Rezoning Transportation Analysis

Petition Number: #2022-109

General Location Identifier: 09709418

Date	Description
11-28-22	First Review (IW)
12-21-22	Second Review (IW)

RZ-1

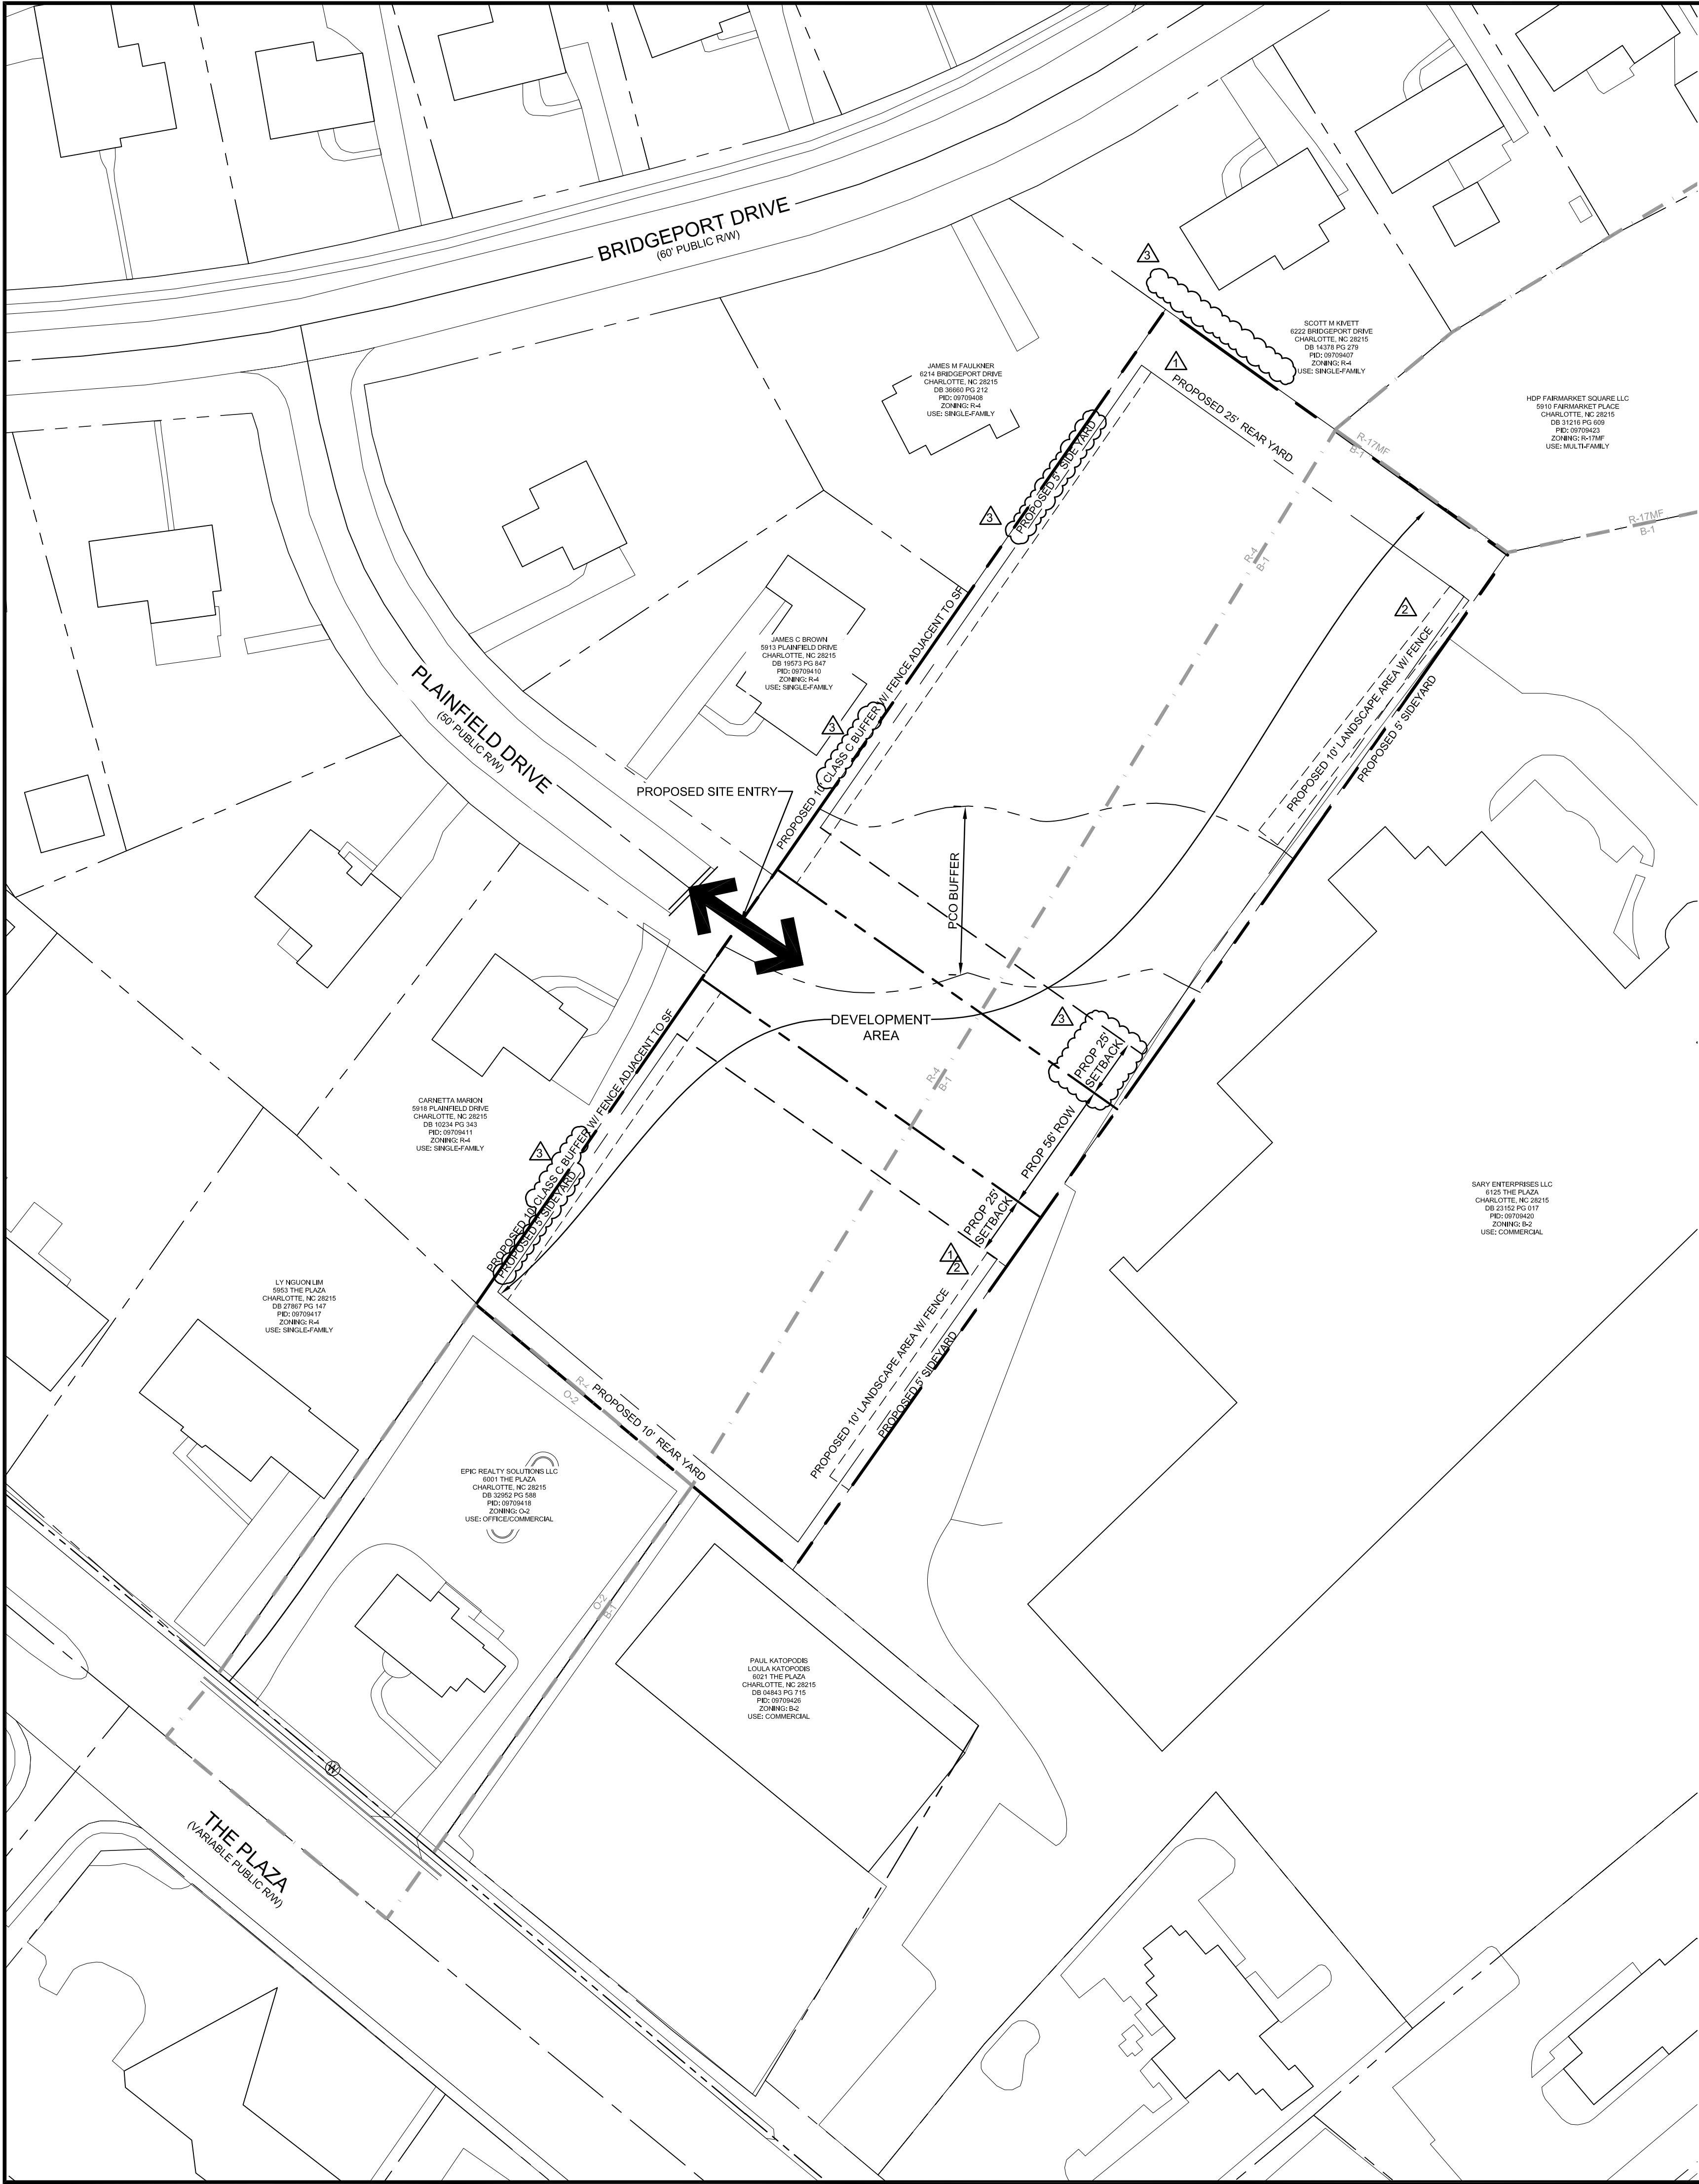
1. ~~**Curblin**~~: The proposed zoning district has a setback measured from back of the existing or proposed future curblin.
- a. ~~**Plainfield Drive**~~: The future location of curb and gutter is in its existing location.

Label and dimension the curb and gutter from the centerline for each road on the site plan.

4. The proposed dwelling units exceeds 12 per acre. Per Chapter 20 Subdivision ordinance, site plan and conditional note(s) revisions are needed to commit to construct an 8-foot planting strip, and 8-foot sidewalk along all public roads. The wider sidewalk also meets the Charlotte WALKS Policy.

Reference (CLDSM standard detail U-02) for residential medium street typical.

Clarifying Comment 12-21-22: Petitioner should add conditional note stating commitment of 8' planting strip and 8' sidewalk along both sides of all public roads. Reference (CLDSM standard detail U-02) for residential medium street typical section.
